DECISION DELEGATED TO HEAD OF PLANNING

Application No: H13-0810-25 **Applicant:** Mr A Woods
Proposal: Proposed Dwelling
Location: Rear Of 18 High Street Moulton Spalding
Terminal Date: 3rd November 2025

GROUND FLOOR PLAN

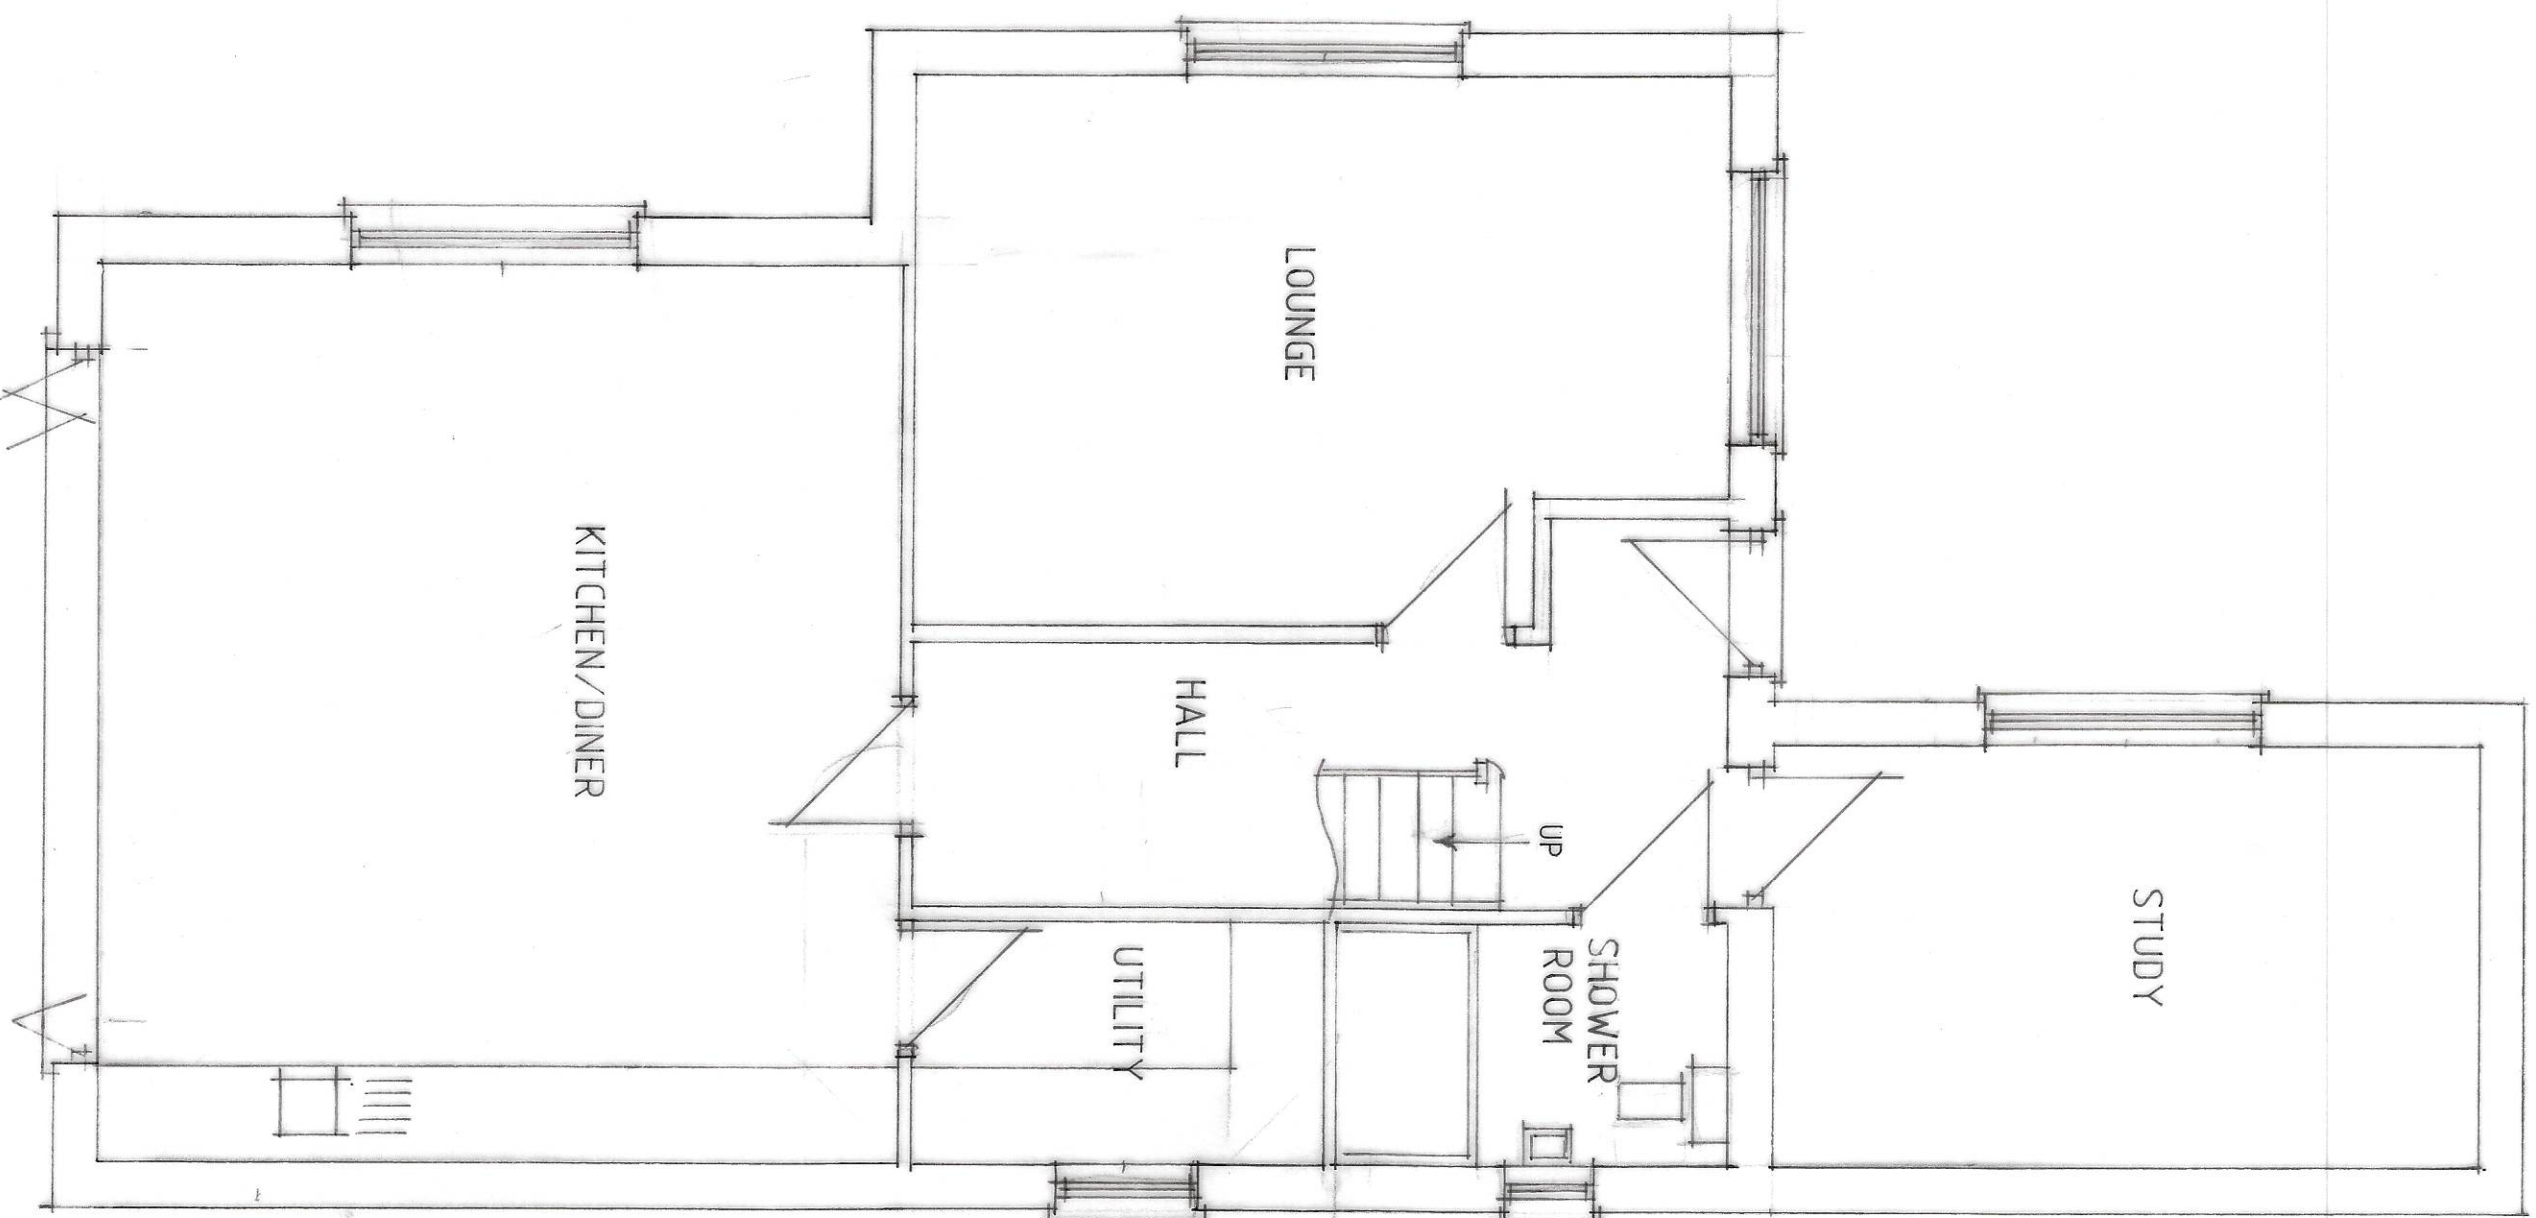
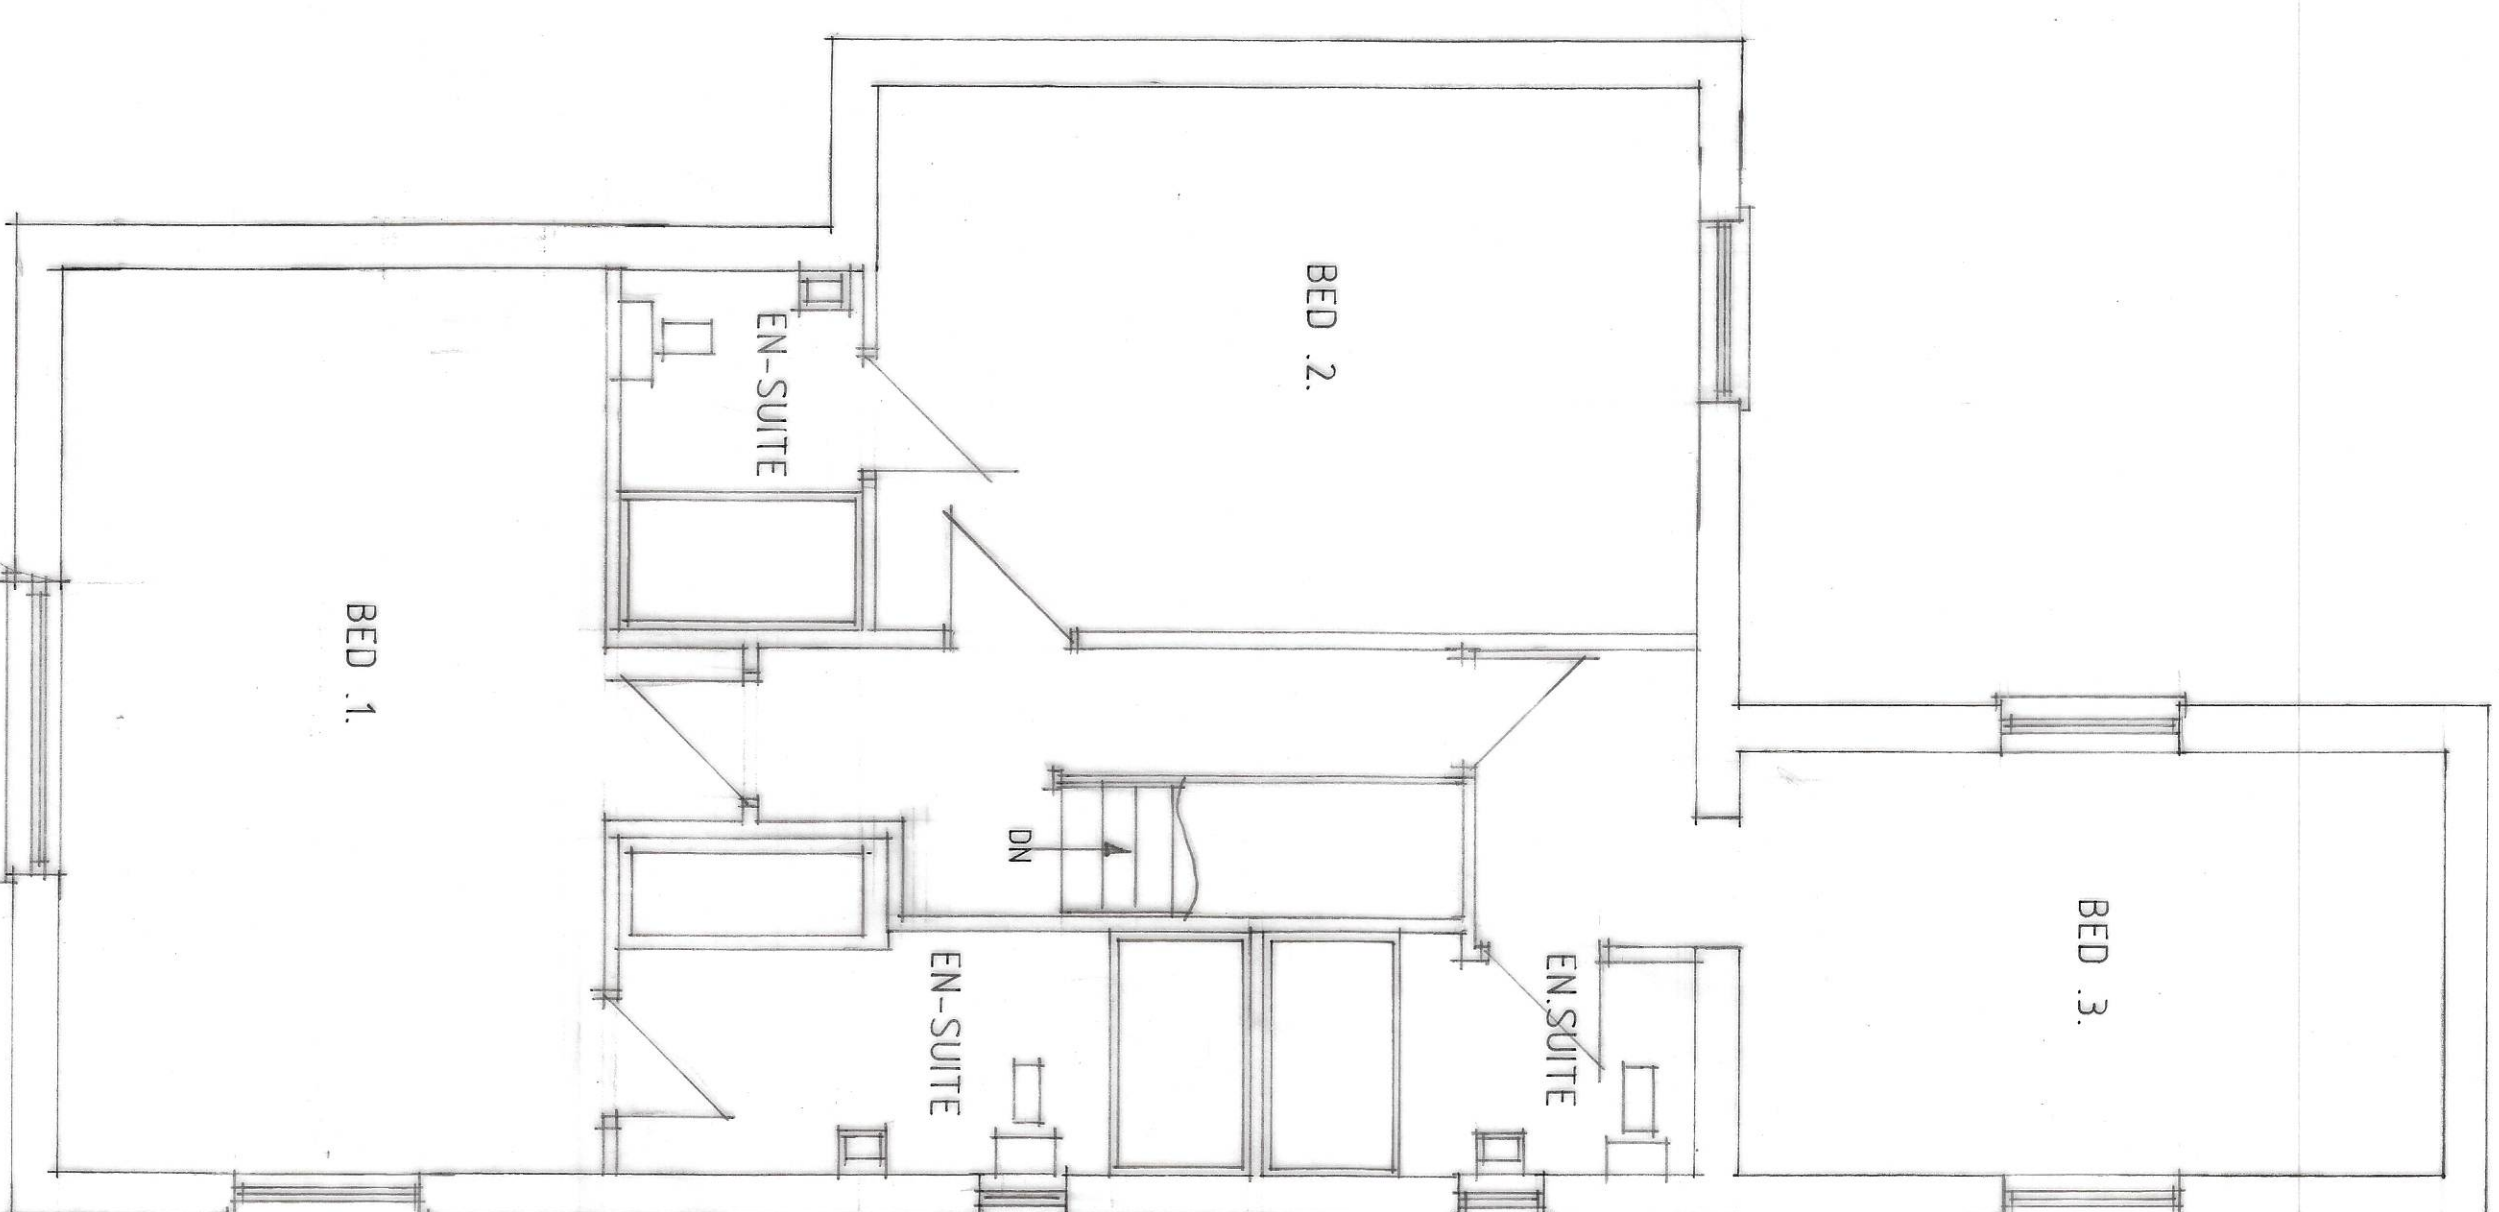
This is a Full application seeking permission for the erection of a single detached dwelling to the rear of 18 High Street, Moulton. The proposed dwelling would be in an unorthodox "T" shape. This gives three widths (going from east to west) of 3.4m, 7.8m and 6.55m. The total length of the building would be 16.35m. The height to the eaves would be 4.45m. The ridge height of the dwelling would vary between the eastern and western section, sitting at 6.4m and 7.65m. The following materials are proposed:

Within the plot itself, the dwelling appears contrived and awkward. It is overly large within such a constrained plot, resulting in an appearance of overdevelopment. The differentiation in roof heights, whilst limiting the visibility of the dwelling, add to this sense of awkwardness.

FRONT

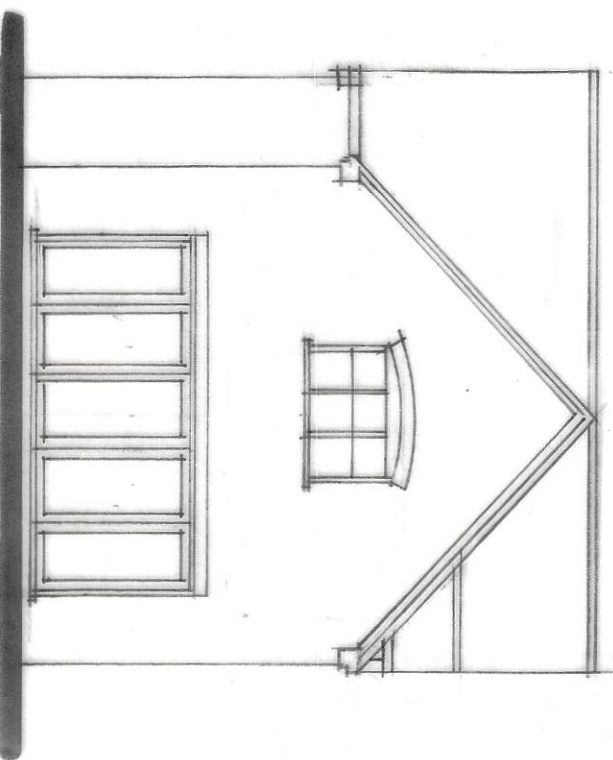
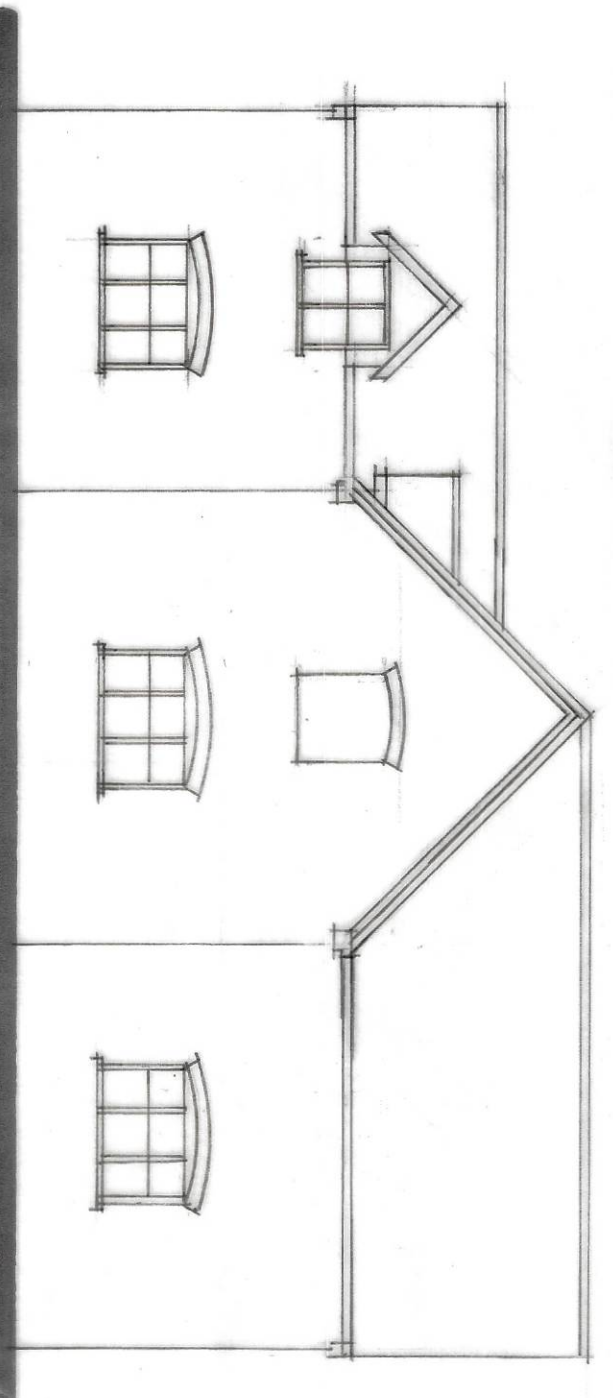
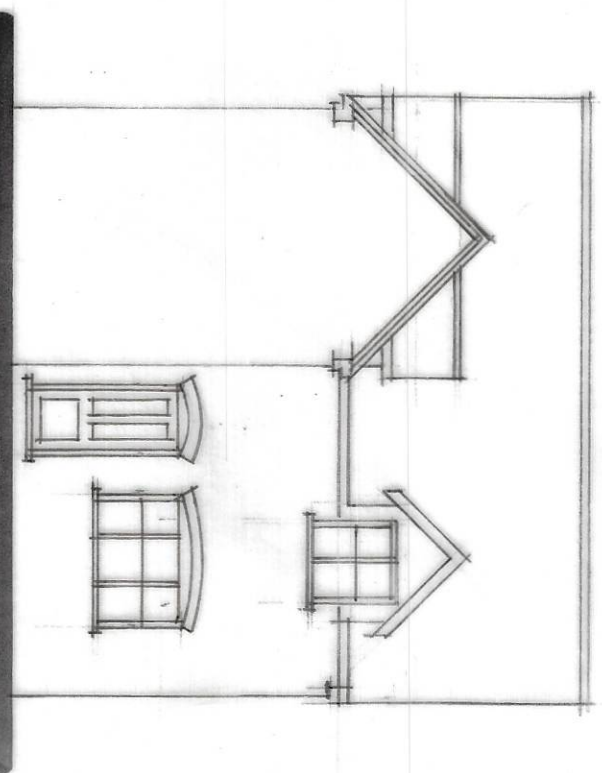
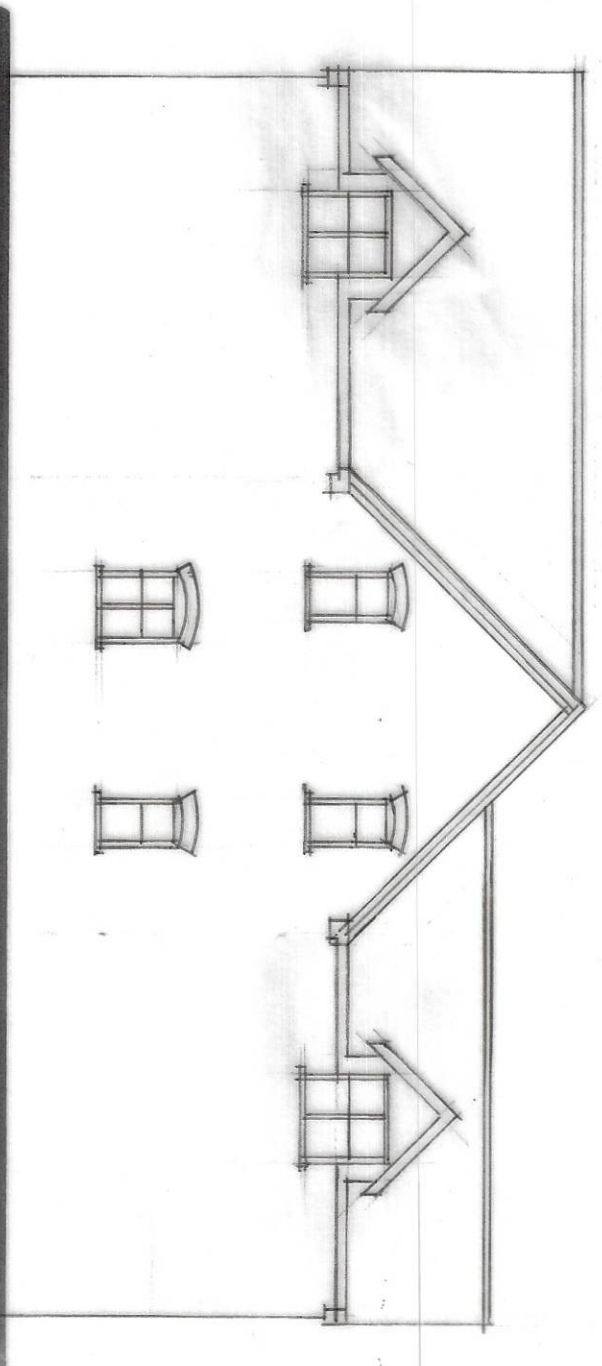
1. Whilst it is appreciated that a significant portion of the proposal is 1.5 storeys in height, there remains a significant portion of the proposal which is full scale 2 storey development, towards the western end of the site, which is arguably the portion of the site which would most require a reduced built form and scale to minimise effects upon the views towards and out of the windmill. This is particularly the case as the site is not only adjacent to the Grade I windmill, but also sits directly between the mill and the nearby Grade I All Saints Church.

2. The plans thus far provided are quite significantly devoid of fine detail, making a full and proper assessment of the final design difficult. Such plans are not uncommon, however, in such a highly sensitive heritage setting, the LPA should be able to reasonably expect a high level of fine detail in plans to be able to make a reasoned justification. Those details should be inclusive of fine details of all architectural features, including brick bond, and full external materials and fenestration details. Given the sensitivity of the setting, I hold that these details should be provided prior to determination, rather than dealt with by condition, as these matters will have a huge and fundamental impact upon the way in which any development on site would impact upon the setting.

The elevation facing the Mill lacks sufficient detailing. Windows and dormers add some interest, yet not adequately sufficient. The result is a bland appearance which fails to add architectural interest to the area.

The anachronistic nature of the design is further demonstrated in the choice of materials. These are relatively typical materials of modern developments, and therefore, would conflict with the established material choices within the area. Grey UPVC in particular would not be a vernacular in a Conservation Area setting or in the setting of a Grade I listed building.

Whilst it is clear that efforts have been made to reduce the height of the dwelling as much as possible, its two storey nature would result in it impeding upon views between the Grade I listed church and Grade I listed Mill. The linkage between the two, particularly when viewed outwards from the Mill's upper levels, would be harmed as a result of this development.
